**OXFORDSHIRE COUNTY COUNCIL'S RESPONSE TO CONSULTATION ON THE
FOLLOWING DEVELOPMENT PROPOSAL**

Application no: 14/01478/F

Proposal: Construction of a road with associated infrastructure within the Heyford Park development.

Location: Heyford Park Camp Road Upper Heyford Bicester OX25 5HD

TITLE: UPPER HEYFORD
 DETAILS: DORCHESTER LIVING ROAD 1 TRACKING
 SCALE: 1:500 @ A1 DATE: JULY 2014 DRAWN: CG CHK: JGF

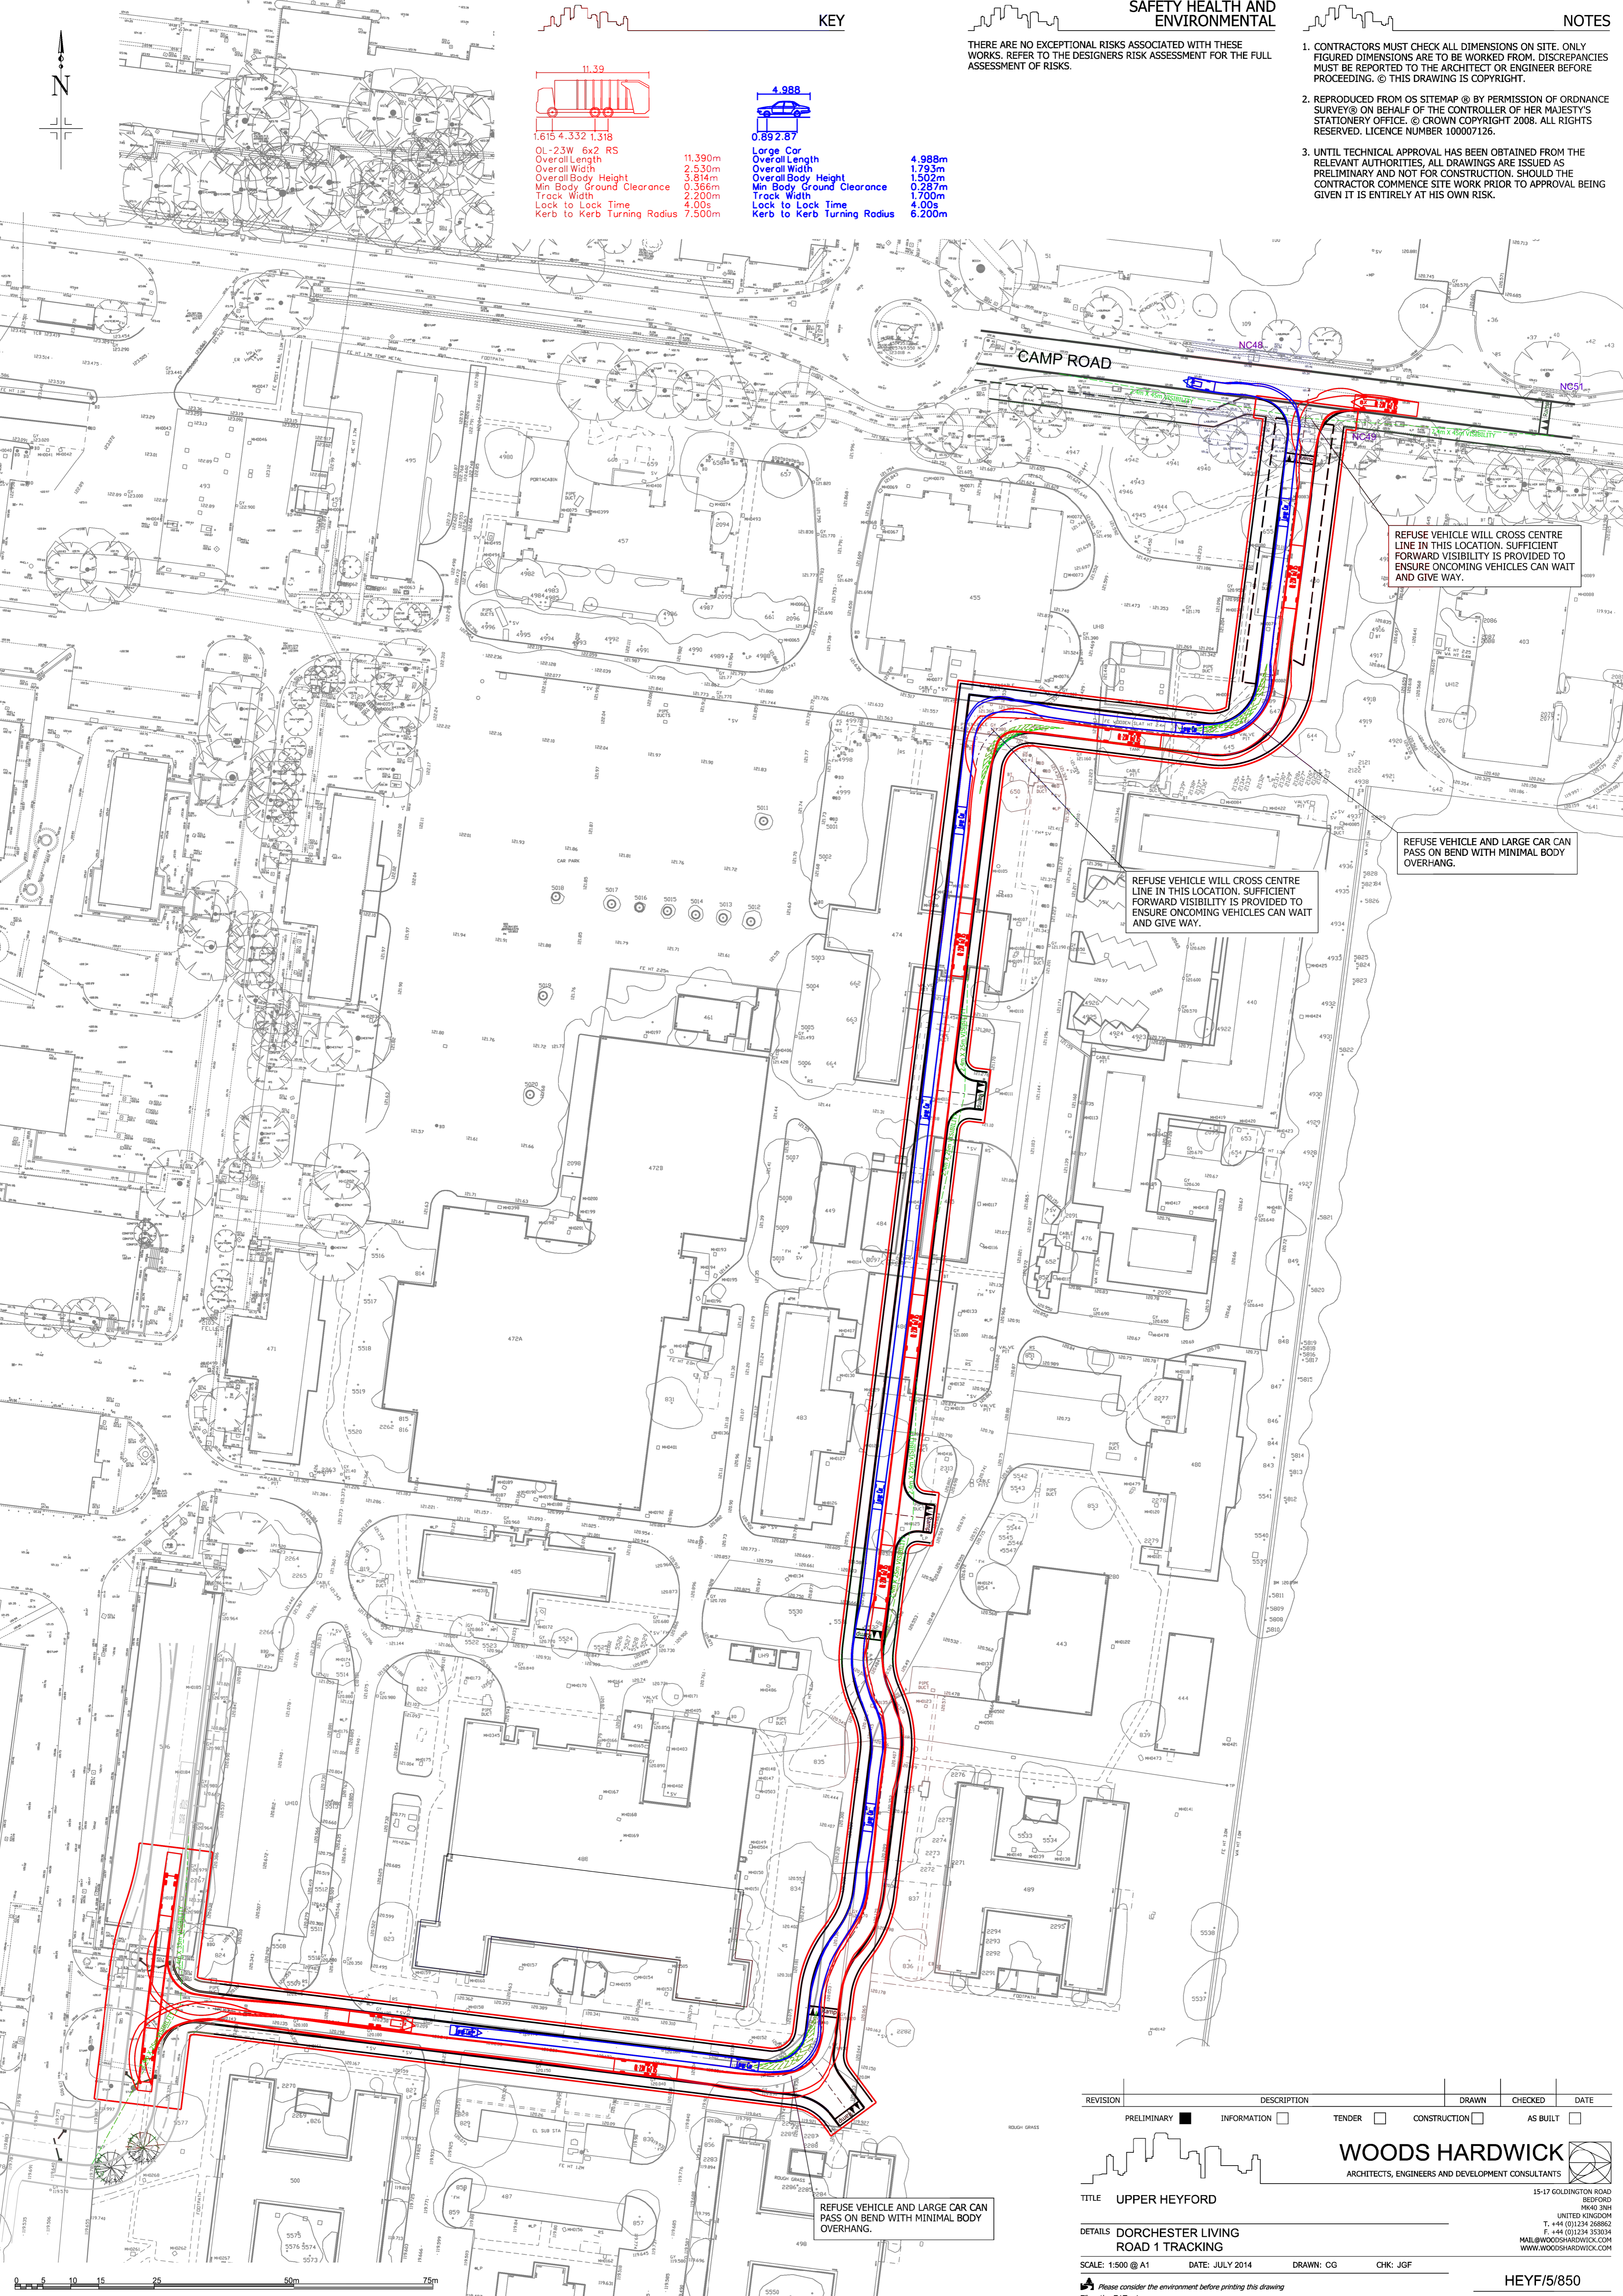
- Following its previous objection to this planning application OCC has now received a revised plan showing acceptable visibility splays at Camp Road and demonstrating the improved tracking of a 10.0m refuse vehicle.
